Ribchester Parish Council

PLANNING APPLICATION No: 3/12/0099

Application: Proposed new agricultural storage building for feed/implements and machinery and livestock.

At: MOOR HOUSE FARM, CLITHEROE ROAD, KNOWLE GREEN

PROPOSED ANCILLARY BUILDING

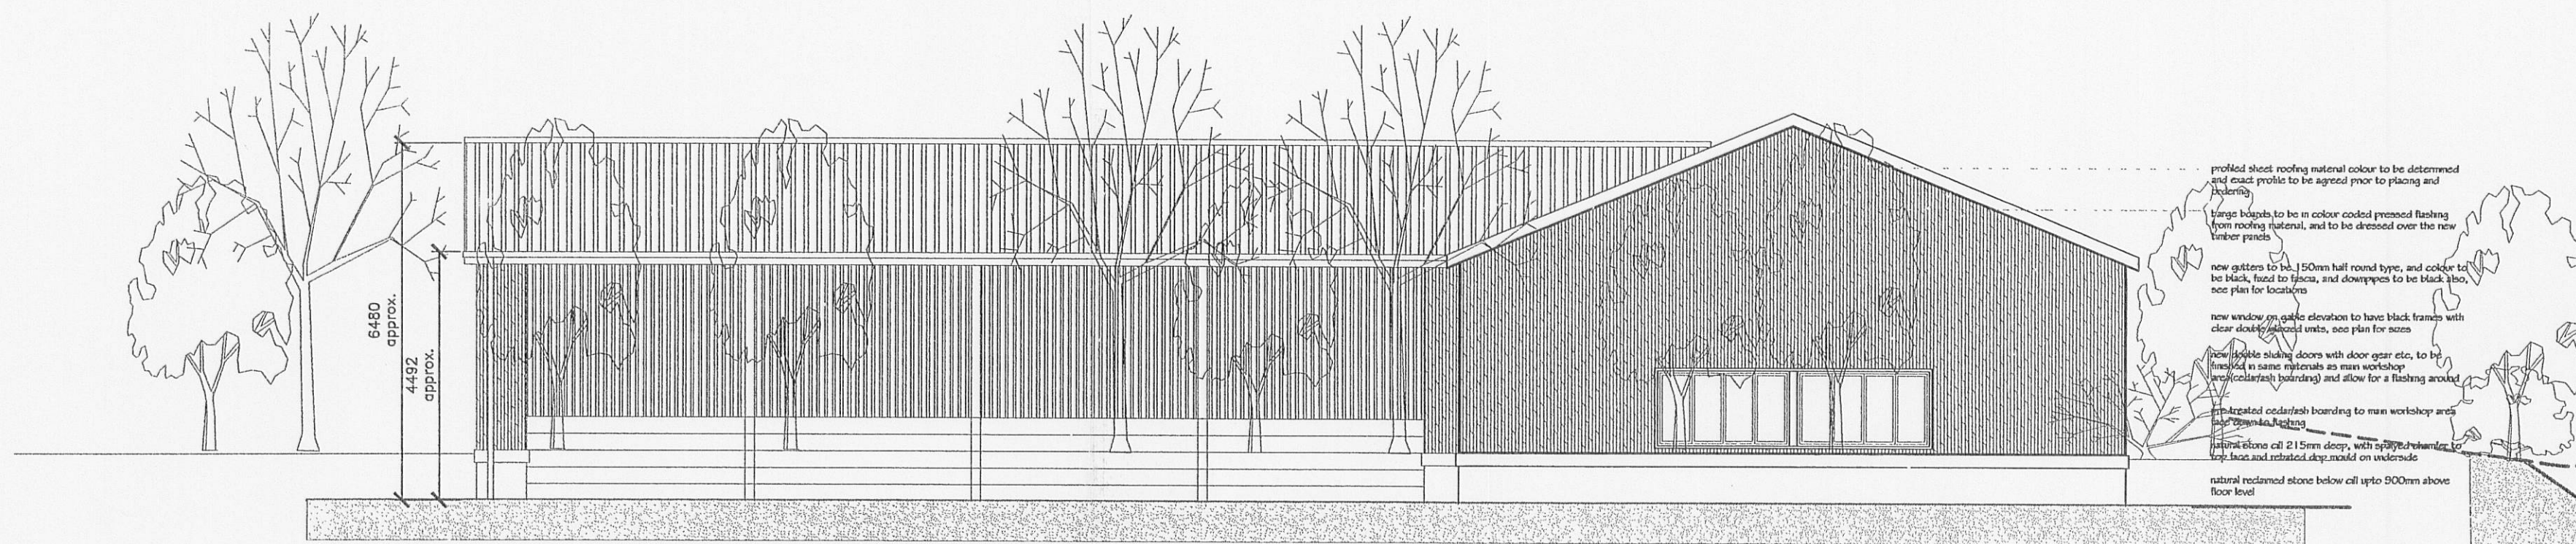
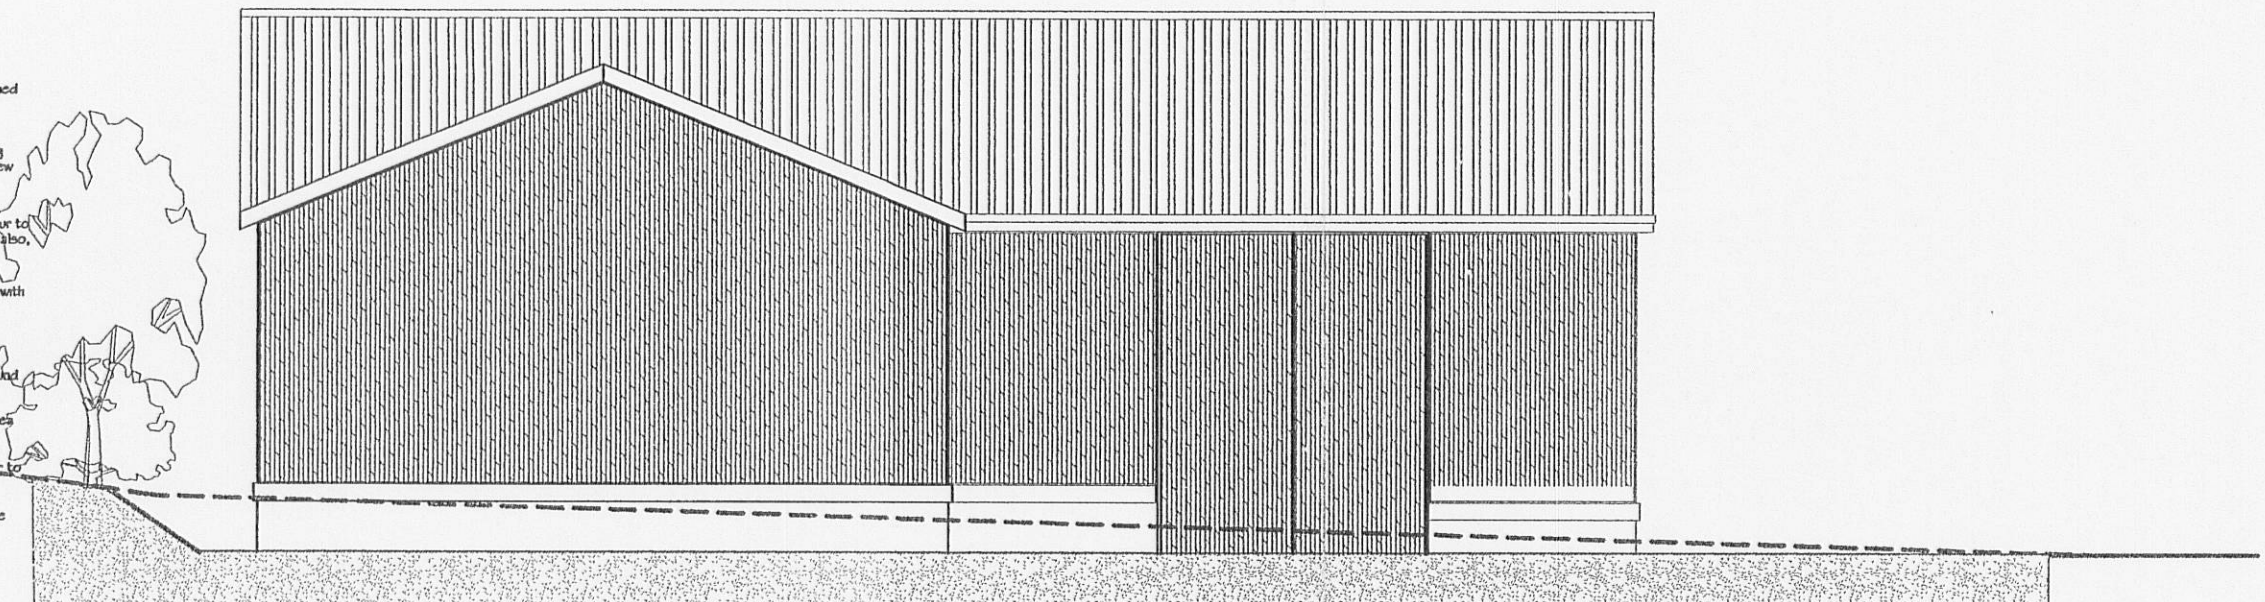
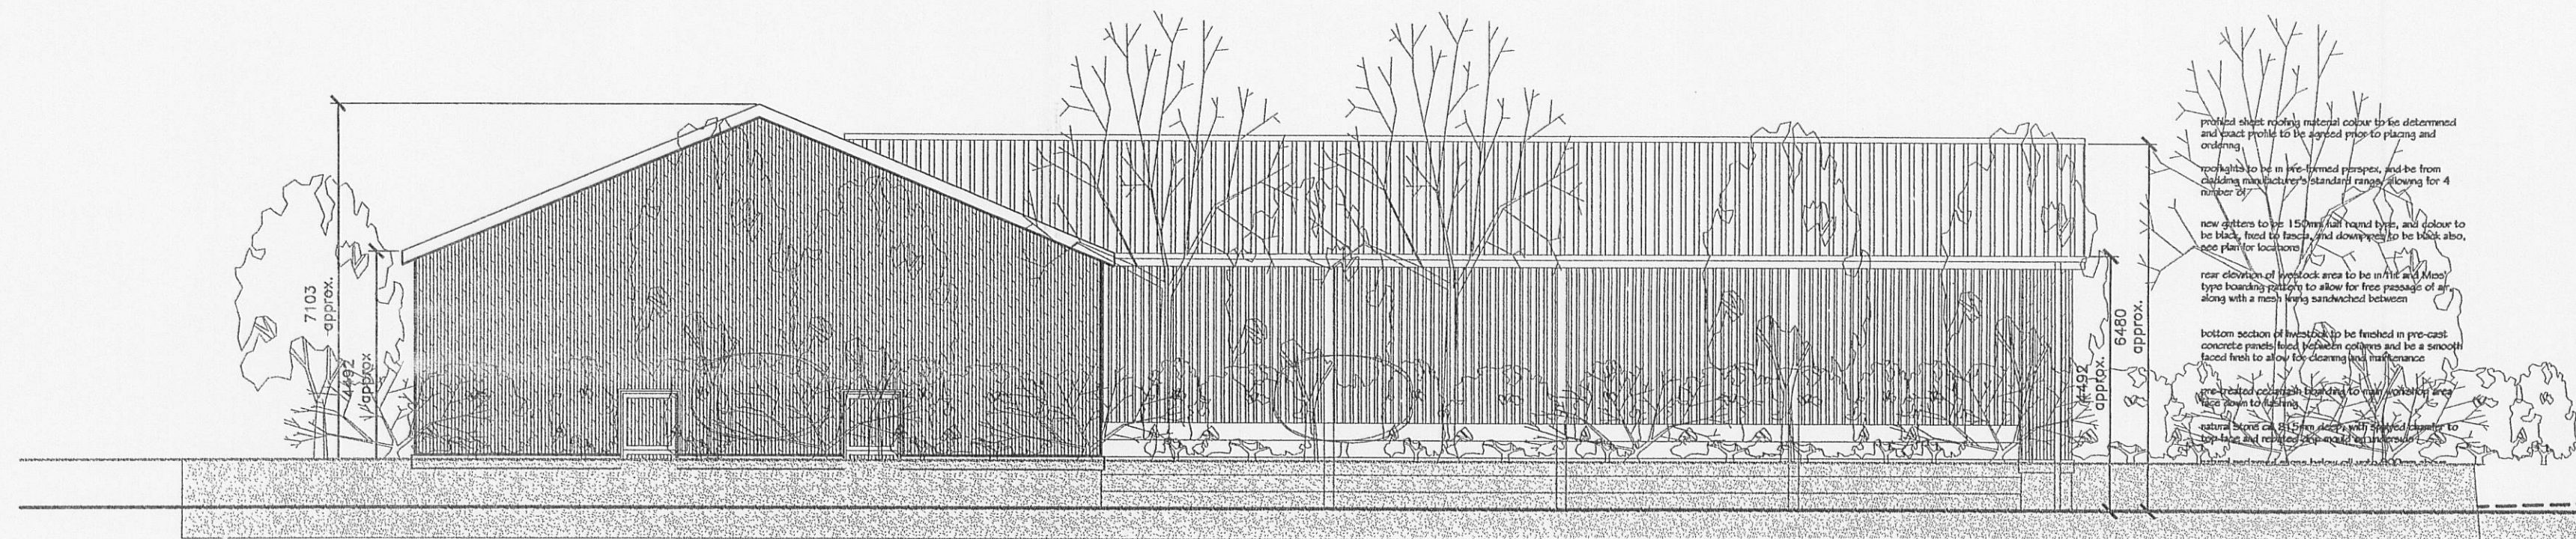
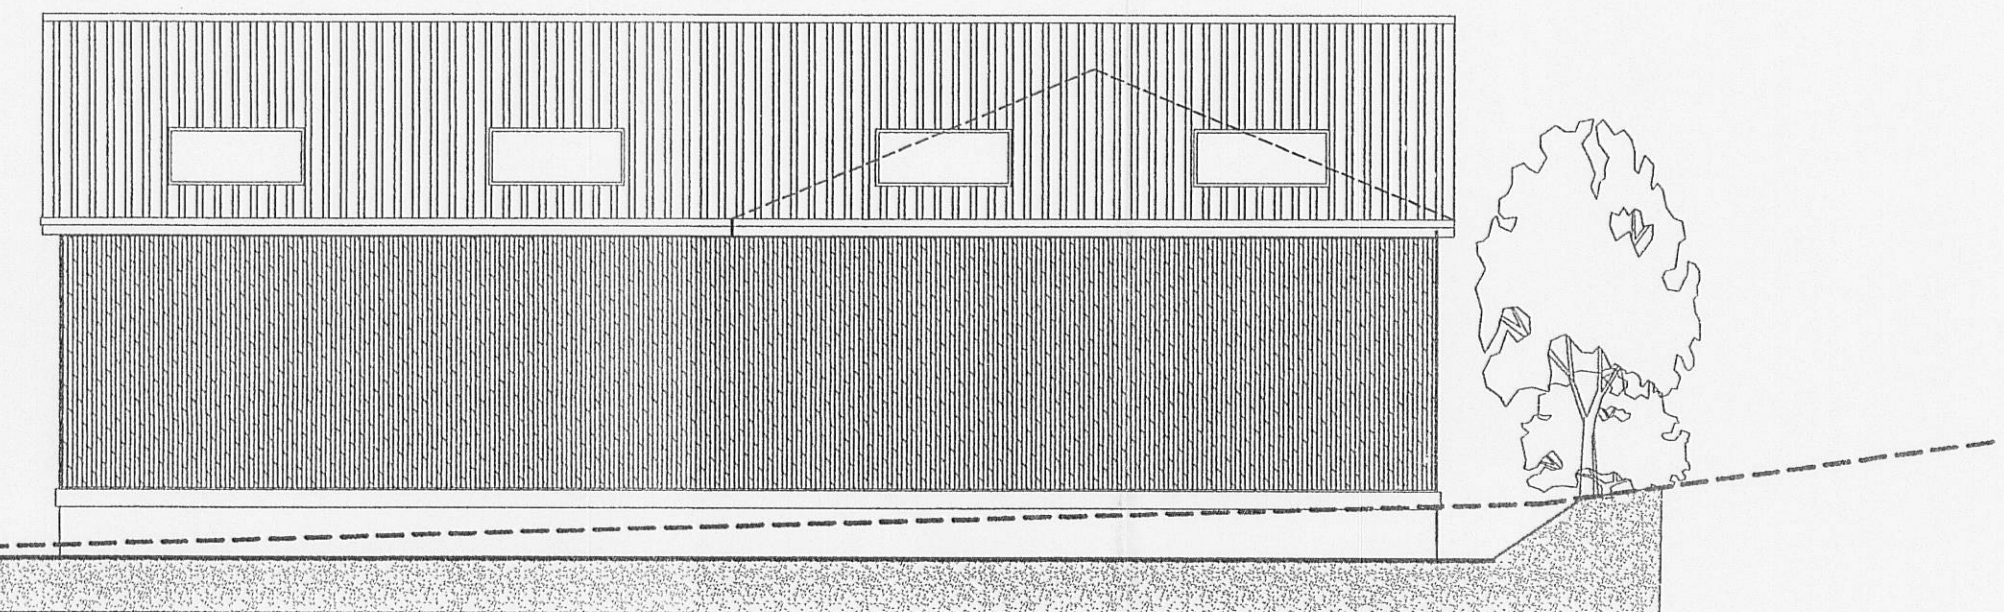
There are two points at issue. Firstly the footprint of the proposed building appears overlarge given the total acreage of the holding. This is then compounded by the height of the roof apex, which at 7 meters brings the possibility of the building standing out from its surroundings and visible from both Clitheroe Road and Stonegate Lane.
